## A303 Sparkford to Ilchester Dualling Scheme TR010036

### 8.11 Statement of Common Ground with the Church Commissioners for England

**STATEMENT OF COMMON GROUND**

**This Statement of Common Ground has been prepared and agreed by (1) Highways England Company Limited and (2) The Church Commissioners for England**

| Drawing Title FIGURE 2.4 RIGHTS OF WAY AND ACCESS PLANS - SHEET 2 OF 4 REGULATION 5(2)(k) and 5(2)(o) | | | | | |

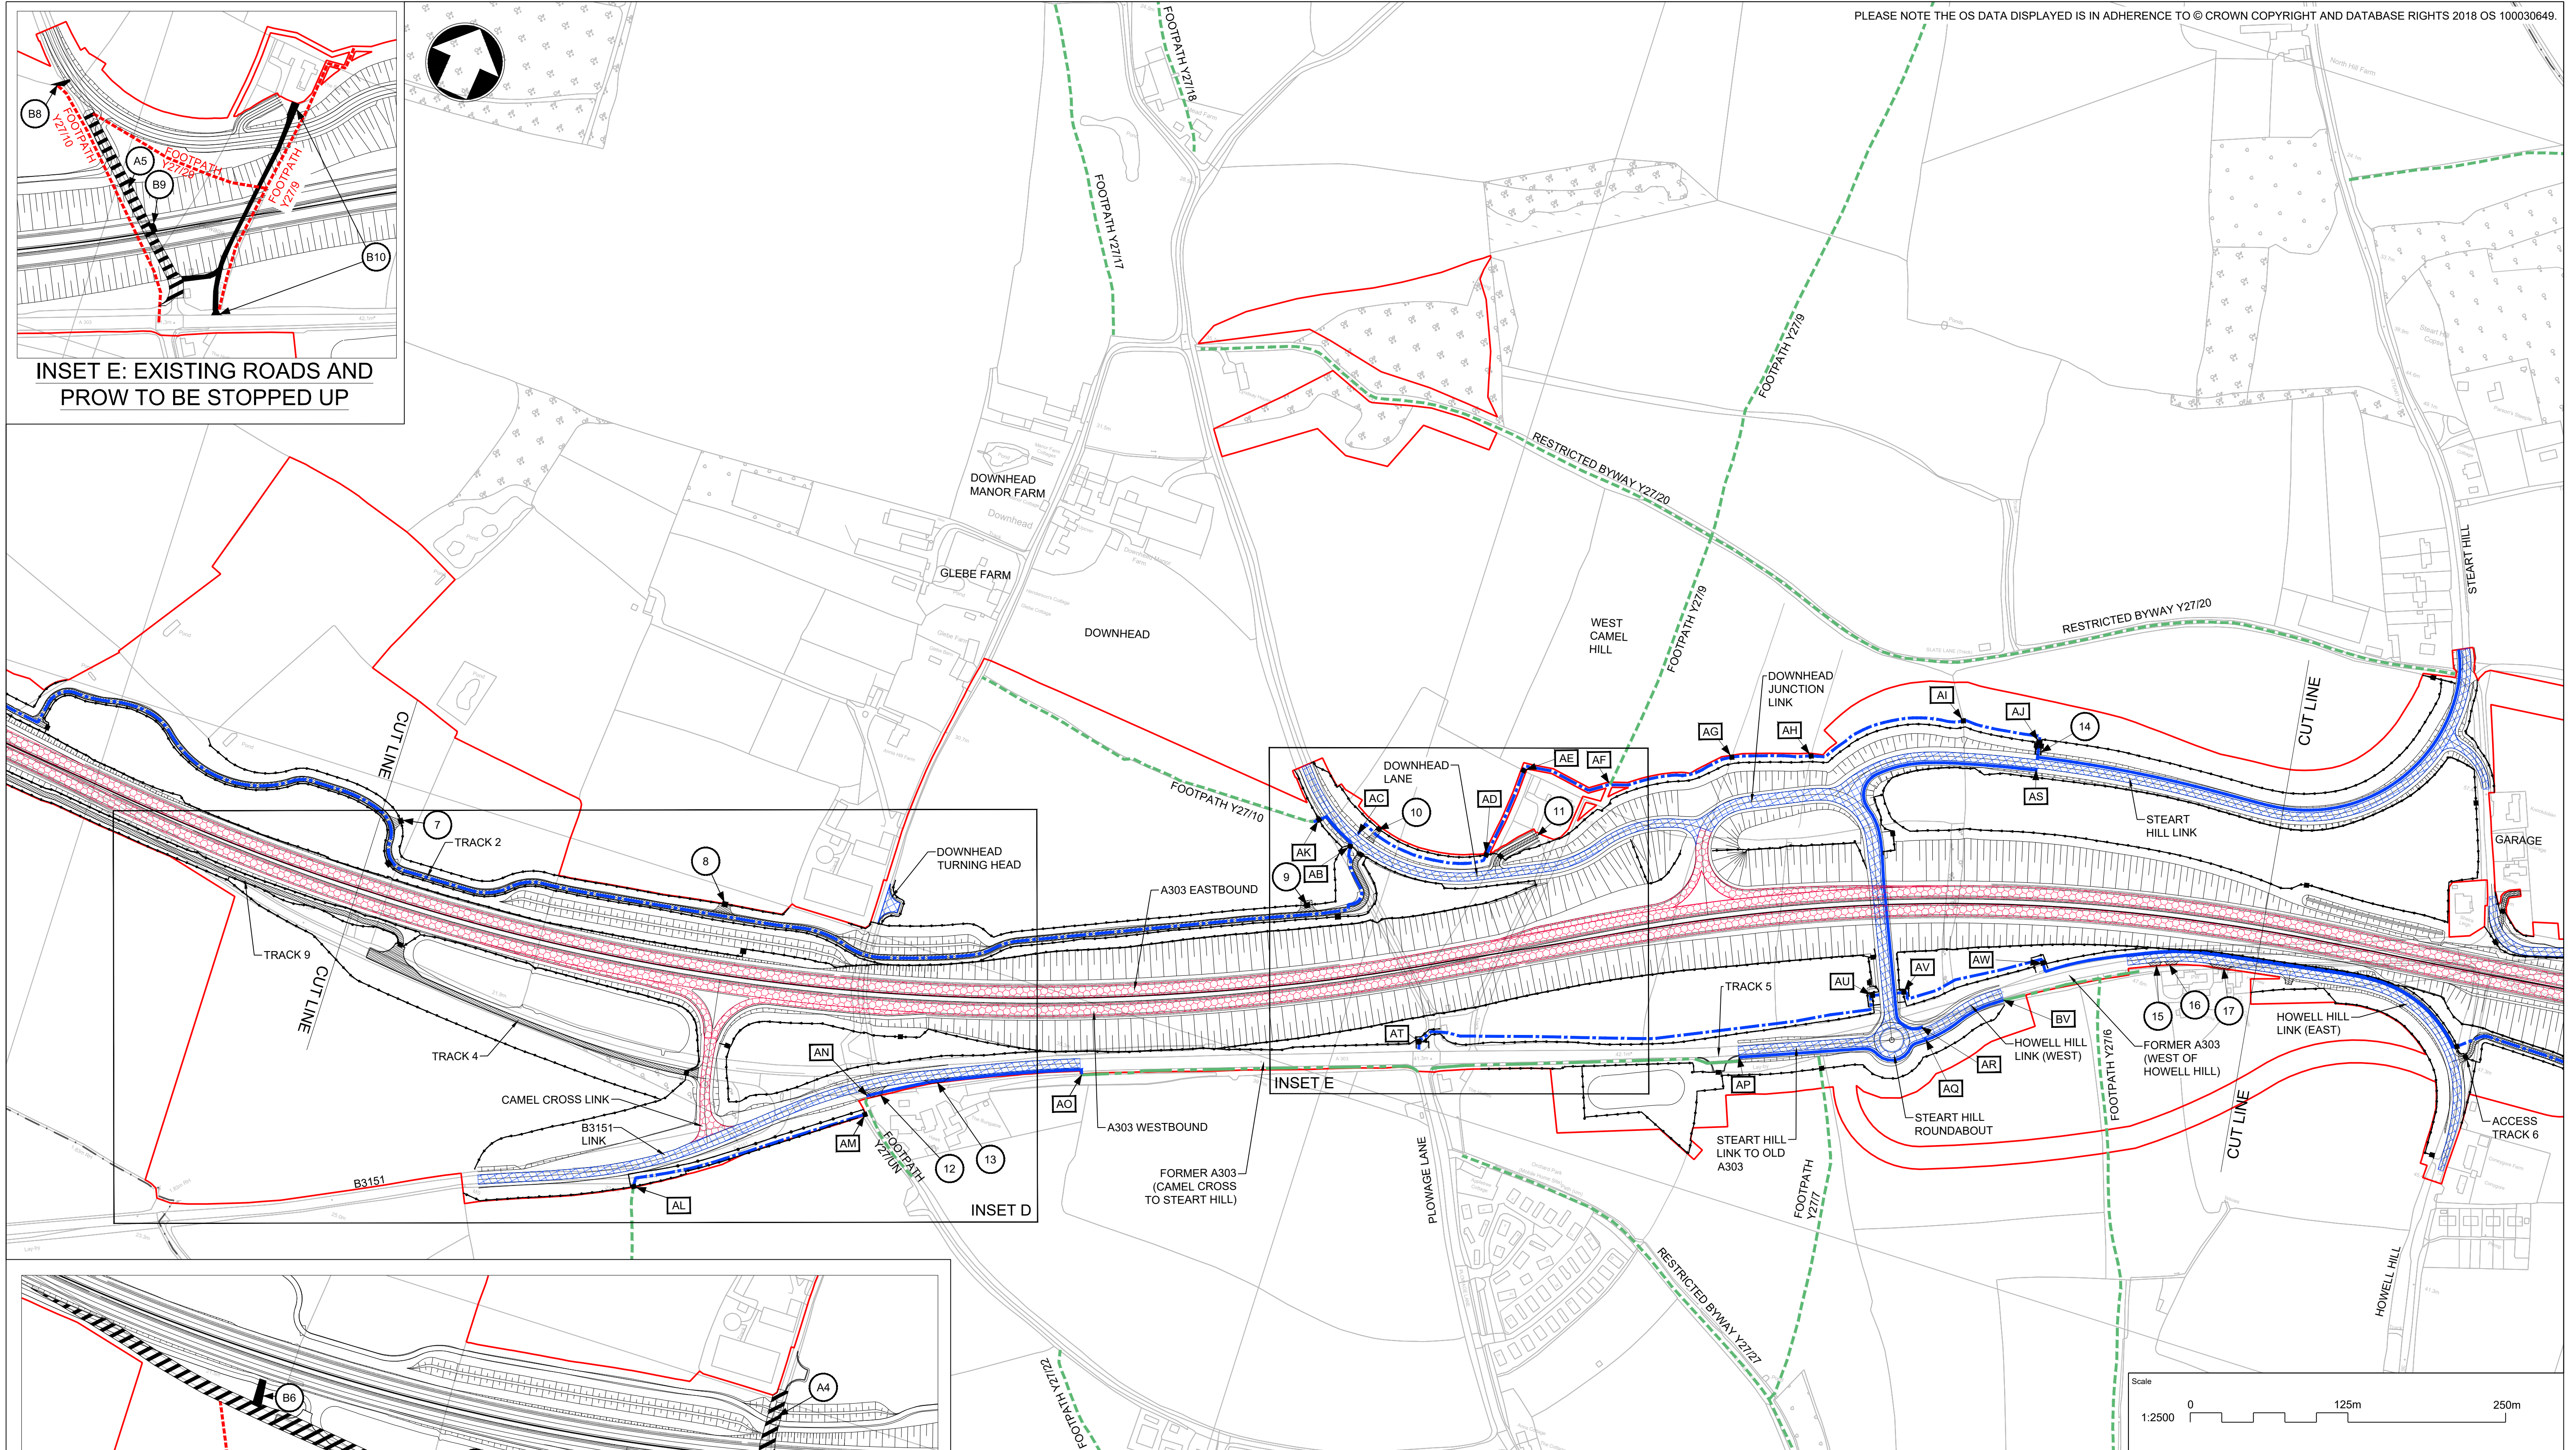
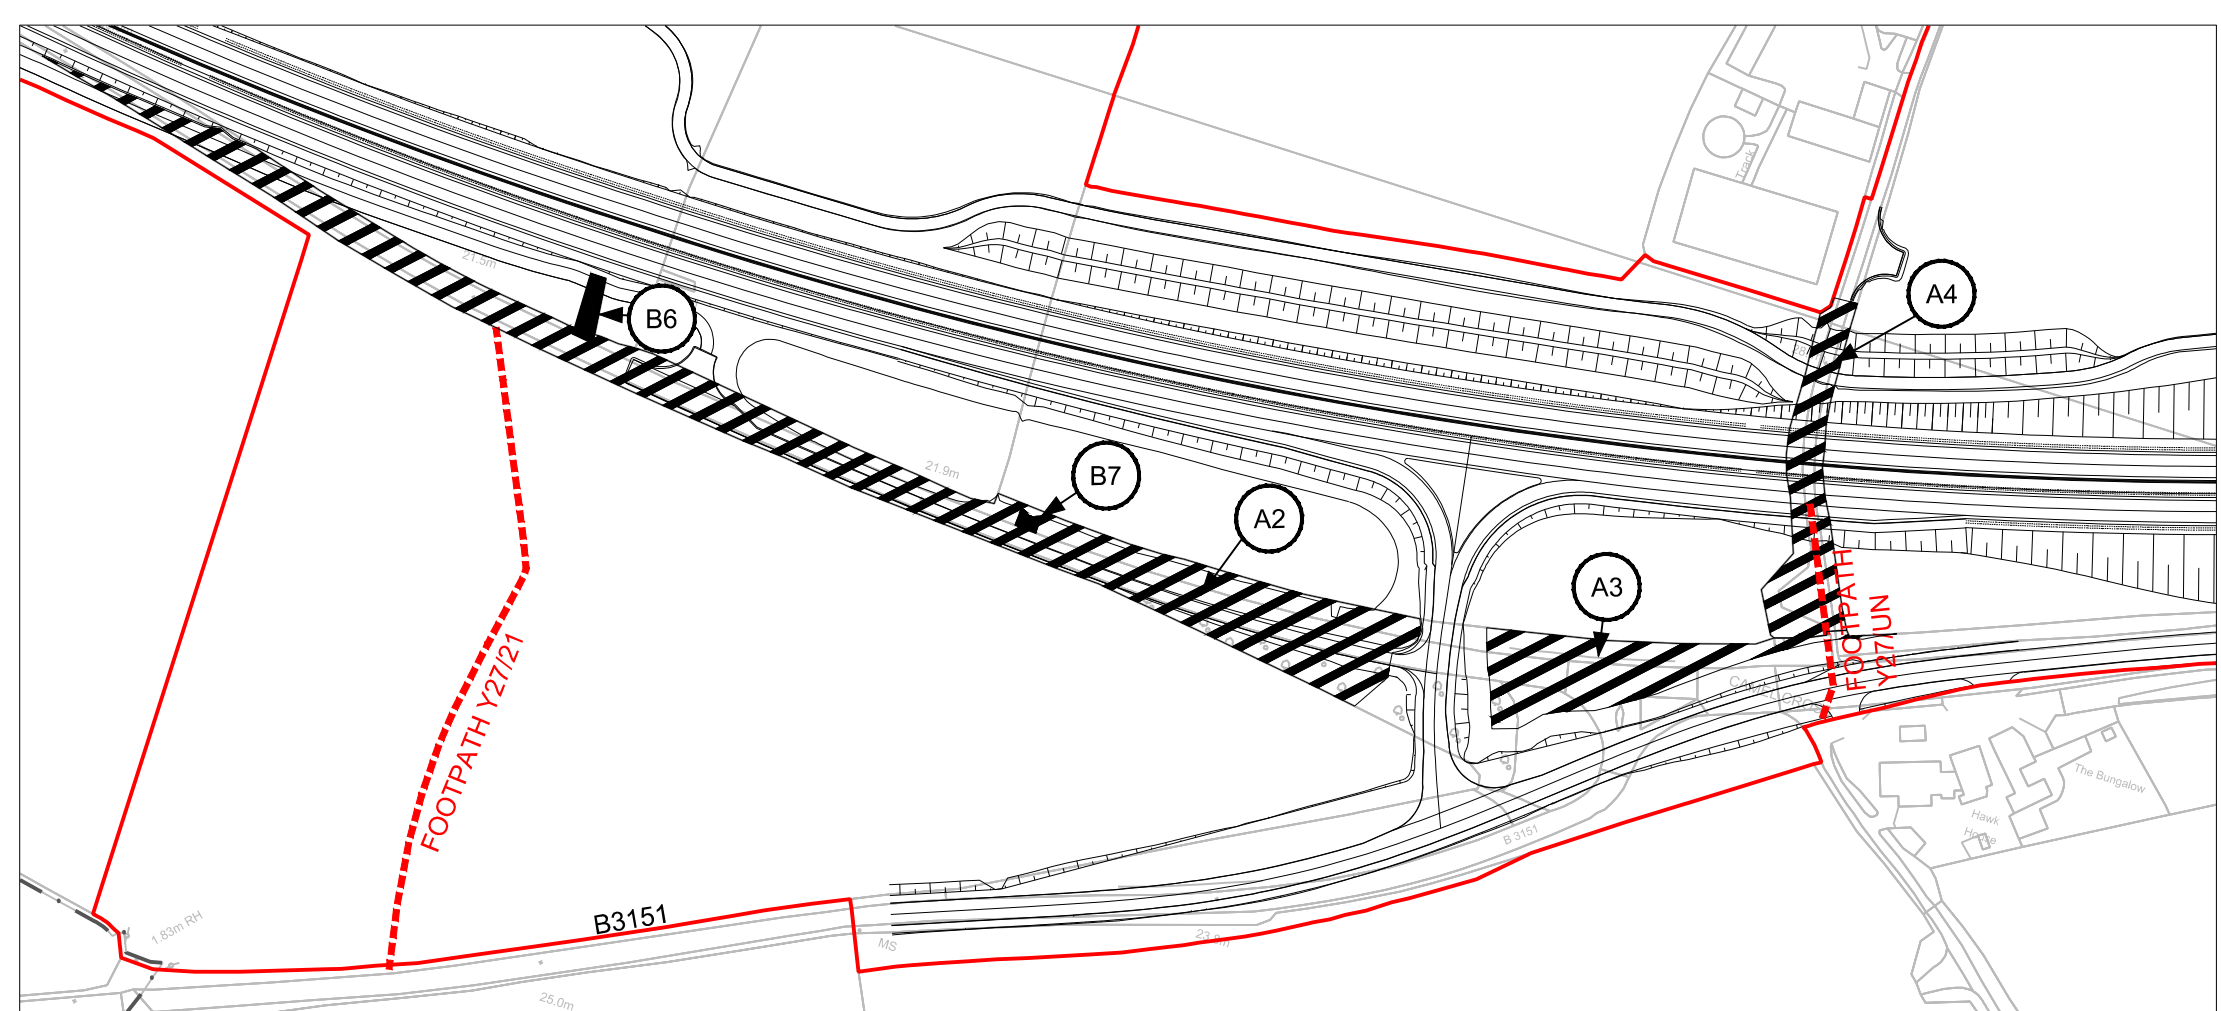
Topic	Ref	The Church Commissioners for England comment	Highways England response	Status
4.1 Accommodation works: Land at Higher Farm (Title Numbers, WS46264, WS46259, WS46247)	(a)	Our client welcomes the inclusion of an accommodation access running from Higher Farm lane to serve their land under title number WS46247.	Noted. Arrangements for access to these plots are shown on <b>sheet 1 of the Rights of Way and Access Plans (REP7-004)</b> . The proposals are for these plots to be accessed from Higher Farm Lane via <b>Tracks 1 and 2</b> . Entry into these plots from Tracks 1 and 2 is at proposed access points <b>2 and 2A</b> .	<b>AGREED</b>

(b)	Our client disagrees that that the access provides them with a suitable alternative means of access. To ensure that the track is suitable for modern agricultural machinery, and provides a similar access provision, our client request the following:	Noted. Specific responses are below:	-

(c)	That the access track is completed to at least 4.5 metres wide with cleared margins on either side of at least 1 metre. This is to allow the safe transition and manoeuvring of large machinery, such as a combine harvester.	Tracks 1 and 2 are 4m wide with 0.5m clear margins either side. The vehicle used to check the layout of the tracks and accesses is a 9m	<b>AGREED</b>

(e)	<p>That the access track is constructed with a suitable hard wearing surface which shall require minimal maintenance. A reinforced concrete surface would be advisable to ensure that the high load of agricultural machinery can be accommodated.</p> <p>It should be noted that the Church Commissioners and their tenants enjoy access to this land parcel directly from the highway, unencumbered, at any time, using a good quality bound surface. If an unbound surface is used this will result in a reduction in value of their retained land.</p>	The specification of Tracks 1 and 2 is currently 200mm of unbound sub-base foundation layer overlain with a surface course of unbound asphalt planings. Highways England would be happy to continue liaising with the Church Commissioners for England on this matter as details of surfacing of access tracks will not be finalised until the detail design stage.	<b>NOT AGREED</b>

(b)	However, proposed access 31 does appear somewhat convoluted, and a long way from the public highway. It is also located in a very wet area of land which will make it difficult to use at certain times of the year. If possible the proposed access should be moved further east. We would welcome further dialogue on this point.	Noted. Highways England will continue to liaise with the Church Commissioners regarding the exact location of access 31 as the design develops.	<b>NOT AGREED</b>

(c)	Proposed access 5 also appears somewhat convoluted, and a long way from the public highway. We request confirmation as to why the accommodation access to this parcel cannot be taken from the west in the direction of Podimore village.	Highways England have investigated the potential for accessing this parcel from the west. It has been determined that, in order to accommodate this within the proposed DCO boundary, a retaining structure would be required. This would be in	<b>NOT AGREED</b>

4.4 Accommodation works for land at Courty & Speckington Farm (North of A303). (Title Number WS46095)	(a)	The Church Commissioners for England welcome the provision of an accommodation access that can serve their land, as the current entrance directly from the A303 will be closed.	Noted. Arrangements for access to this plot are shown on the <b>Rights of Way and Access Plans (REP7-004)</b> . The proposals are for this plot to be accessed from the proposed Downhead Lane <b>Track 2</b> . Entry into this plot from Track 2 is at proposed access points <b>8</b> .	<b>AGREED</b>

(b)	The Church Commissioners request that the specification for this accommodation access as it leads from its most eastern extent to their land in the west, is the same as noted in respect of accommodation access serving the land at Higher Farm (see above comments).	Track 2 is 4m wide with 0.5m clear margins either side. The vehicle used to check the layout of the tracks and accesses is a 9m long combine harvester with a track width of 3.7m.	<b>AGREED</b>
			The gate currently specified for access 8 is a steel double field gate with a post-to-post clearance of 5.02m. Highways England would be	<b>AGREED</b>
